Mr Joshua Graham
Managing Director
PF FORMATION PTY LIMITED
1 Patricia Fay Drive
Maroota New South Wales 2756
19/11/2021

**Hitchcock Road Quarry Modification 1 (MP 06_0104 Mod 1)
Request for additional information**

AREAS TO BE CLEARED AND NEW PLANTINGS (STRATEGY A)

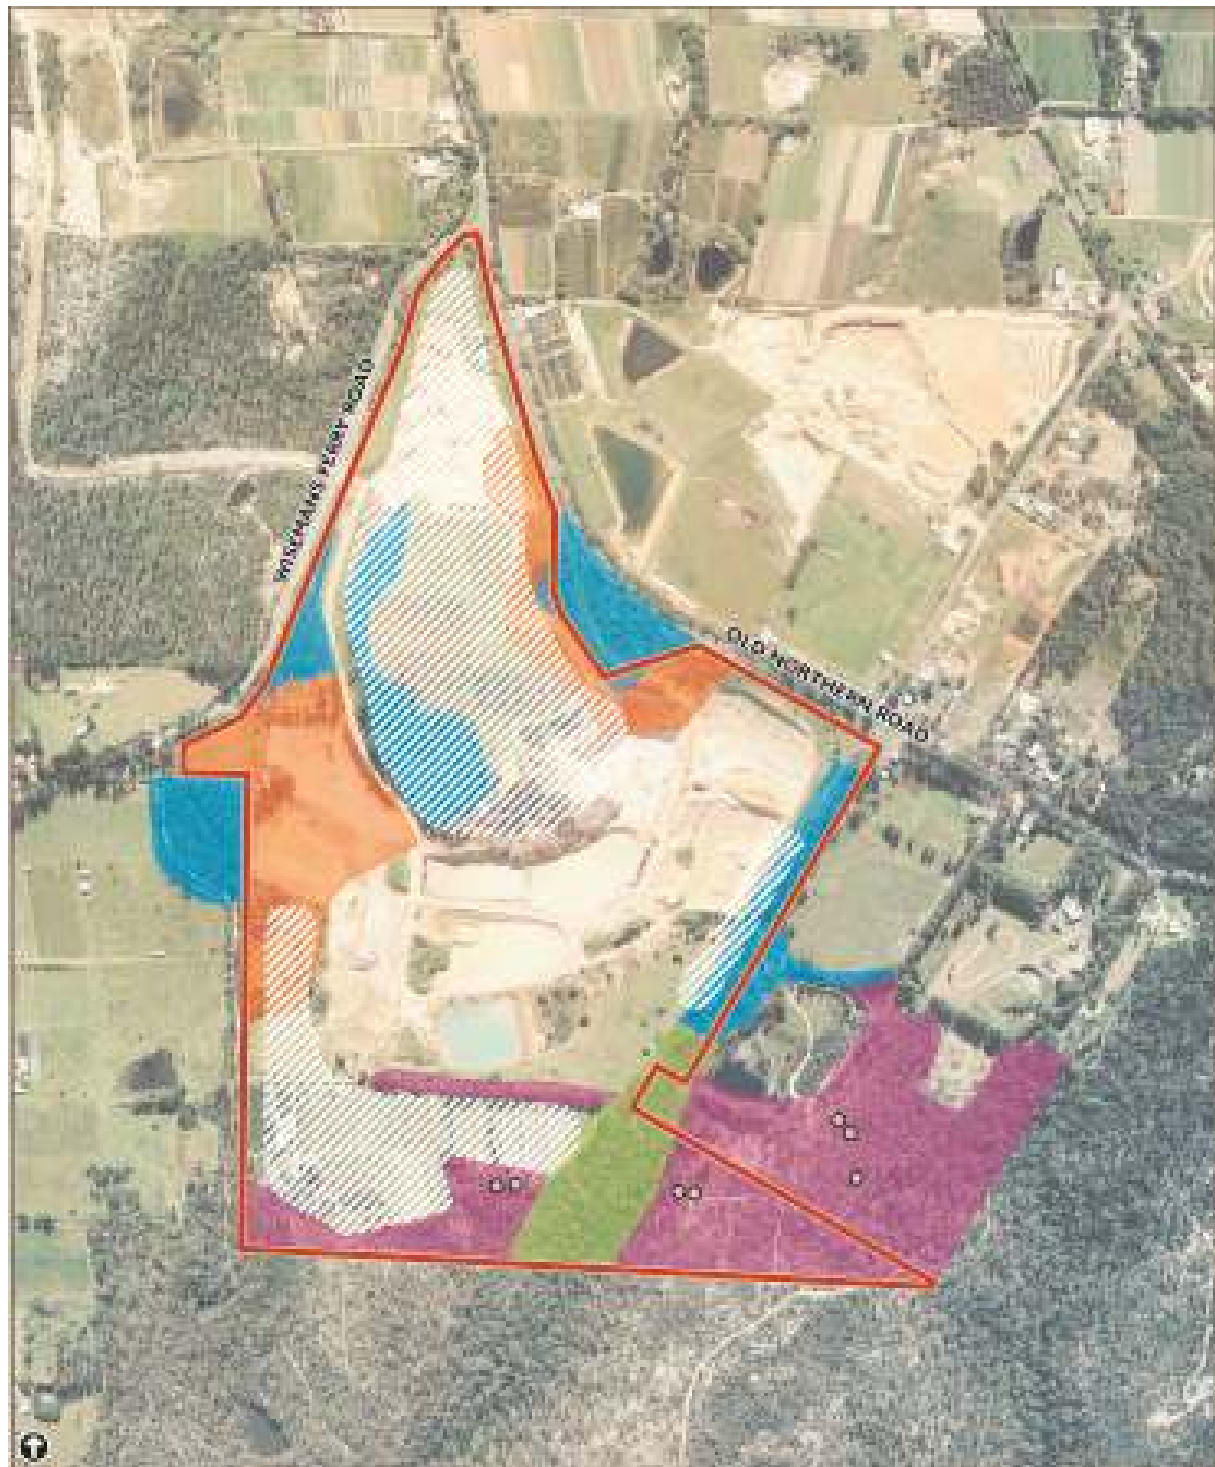
Regarding point 2 in the attachment of that letter, the information you provided in your response dated 3 November 2021, did not address the matters raised regarding vegetation being sought for removal versus what has been approved for removal and how this relates to the biodiversity offset proposed.

Please provide the information or you may request to remove this element of the application, by Friday 26 November 2021. If you cannot meet this deadline, please provide an alternative timeframe for providing this information.
